**Consultation Response from KC,
Highways Development Management**

2025/91054 land south of, Swallow Lane, Golcar, Huddersfield, HD7 4NB

**Discharge of details reserved by condition 23 (secure cycle parking) on previous permission
2023/92749 for variation of condition 2 (plans and specifications) on previous permission**

location STANDARD DETAILS			
title Bike Rack - Fence Mounted			
scale 1:20	drawn by JHY	date MAR 2025	
drawing no. JHY-SDL-0005		rev -

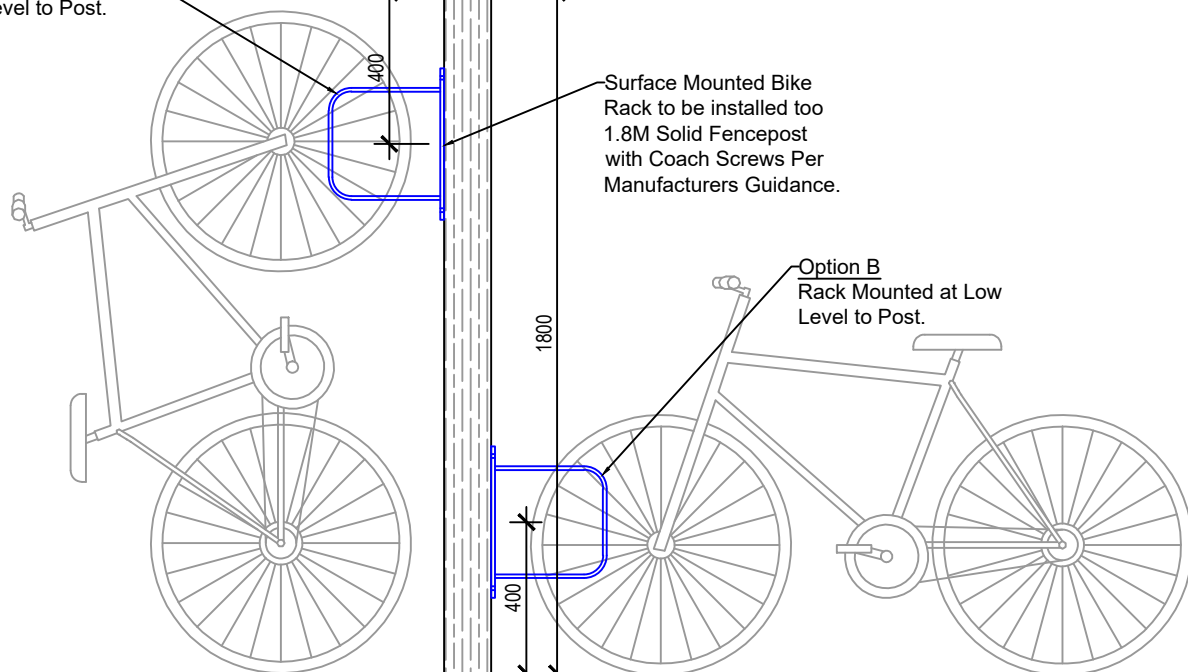
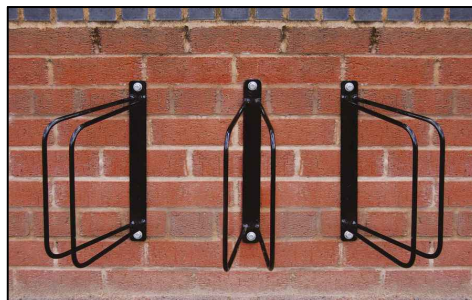
The applicants have provided plan number JHY 1354 200S Site Layout showing the location of the proposed bike stores and JHY SDL 0005 showing details of fence mounted bike racks.

Highways Development Management would have ideally preferred covered and secure storage but given the wording of the condition these proposals are on-balance considered acceptable.
